**Consultation Response from KC,
 Policy**
2023/93386 Spen Valley High School, Roberttown Lane, Roberttown, Liversedge, WF15 7LX
Erection of new office building and extensions and alterations to existing Lodge building
Date Responded:
Responding Officer: AW
Responding Ref:

Proposed Block Plan

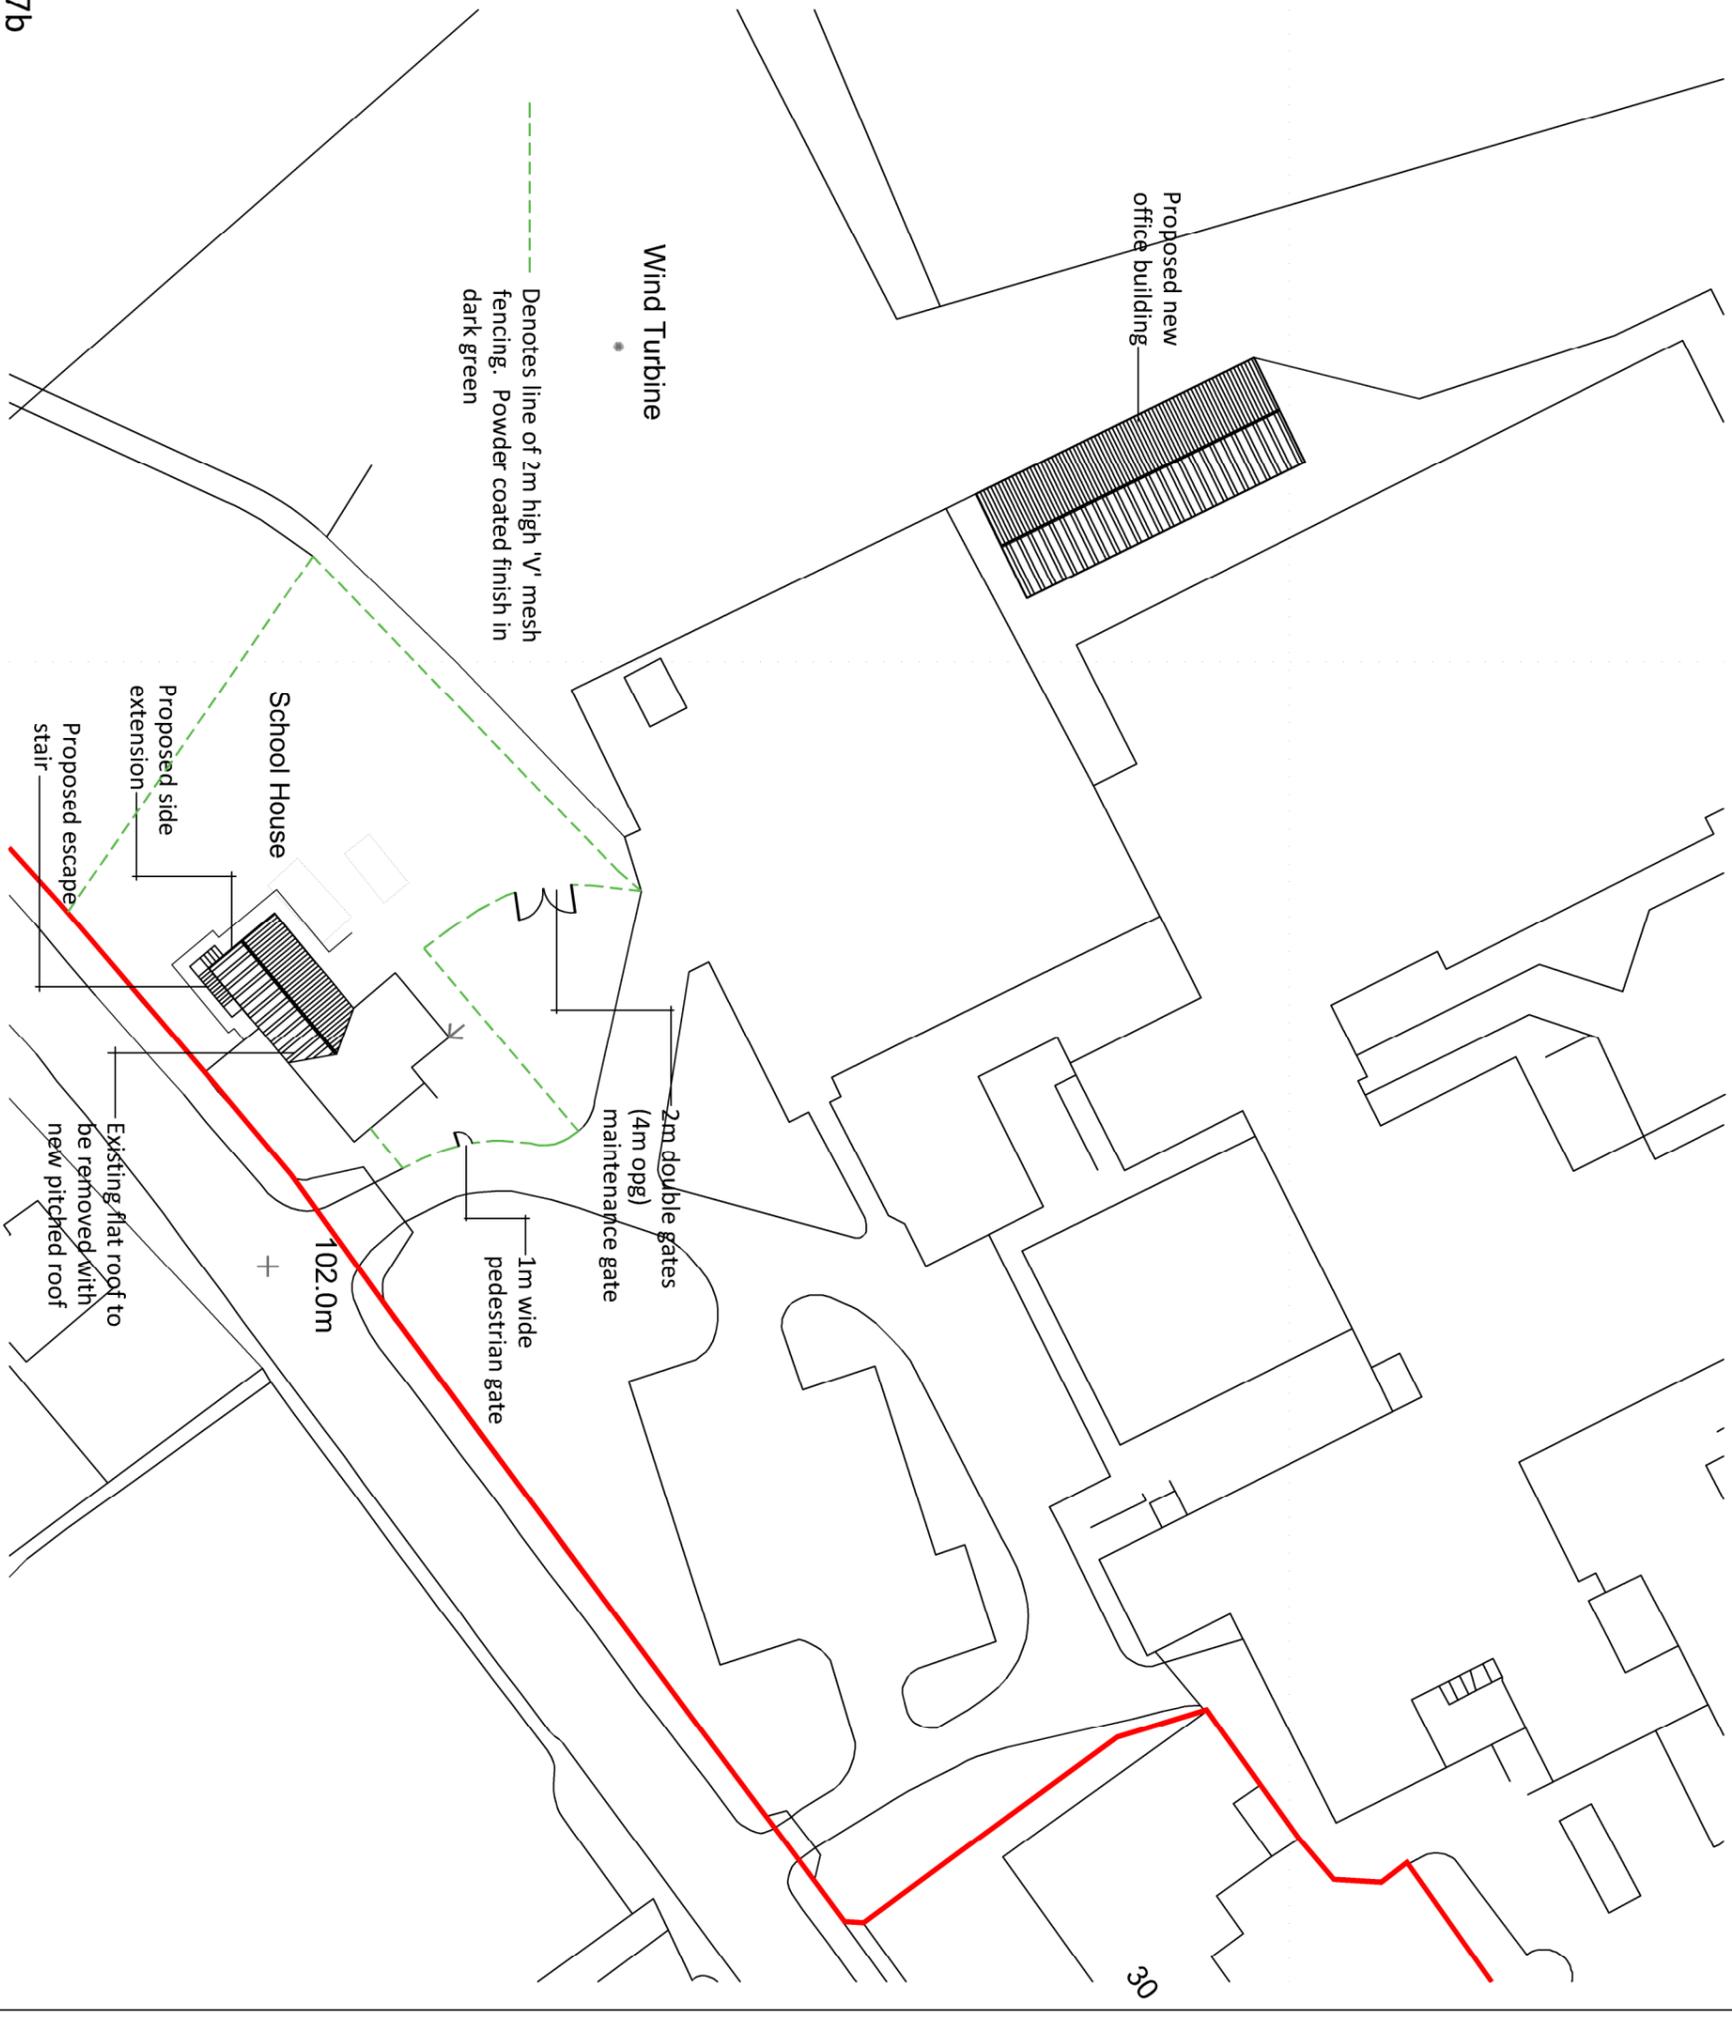
In regard to the proposed V-mesh fencing, the design and access statement submitted to support the application states that the fencing "is to assist in containment and security as part of the overall proposals". From reviewing the plans, it is unclear as to whether the proposed fencing, and the groundworks required for its installation, would result in a loss of green space. For the most part, the proposed fencing appears to adjoin a surfaced path that borders an area of existing green space, however to the north of the school lodge building, the plans show that the fencing would cut across an area of green space, which could result in a marginal loss of UGS – contrary to LP61. As before, in these circumstances, given the site to which this application relates is in educational use, weight should be given to NPPF paragraph 99(a), and any loss of green space that may occur, should be weighed against increased site security that the fencing would provide.

The plans show that a section of the 2m V-mesh fencing that is proposed under this application would be positioned within the green belt. The proposed new fencing would replace some existing fencing that currently stands to the west of the school lodge building, southeast of the hard standing path. NPPF paragraph 154 states that local planning authorities should regard the construction of new buildings as inappropriate in the green belt, unless specific exceptions can be satisfied. For the purposes of NPPF paragraph 154, the fence should be regarded as a building and therefore falls to be considered under this paragraph. The exception at paragraph 154 d) relates to the replacement of a building, provided the new building is in the same use and not materially larger than the one it replaces. This is supported by Local Plan policy LP57 (the extension, alteration or replacement of existing buildings). In this case, the proposed building would be in the same use as the one it is set to replace; however, it is considered that the new fencing would be materially larger than what currently exists. The indicative plans illustrate that the proposed new fencing would be longer than the fencing that currently stands, and there would be approximately 31m of 'new fencing' standing to enclose land within the green belt. In turn, the exception at NPPF paragraph 154 d) does not apply, and the fencing would constitute inappropriate development in the green belt.

Giving regard to the openness of the green belt, in this instance, while the fence would be materially larger than the fencing it is set to replace thus would fail to satisfy the exception at paragraph 154 d), it would be enclosing the operational grounds of Spen Valley High School. The openness of the green belt in this particular location is already harmed, so while the new fencing would impact the openness of the green belt given additional land is to be subdivided and enclosed, it is considered that the impact, in this case, would be limited.
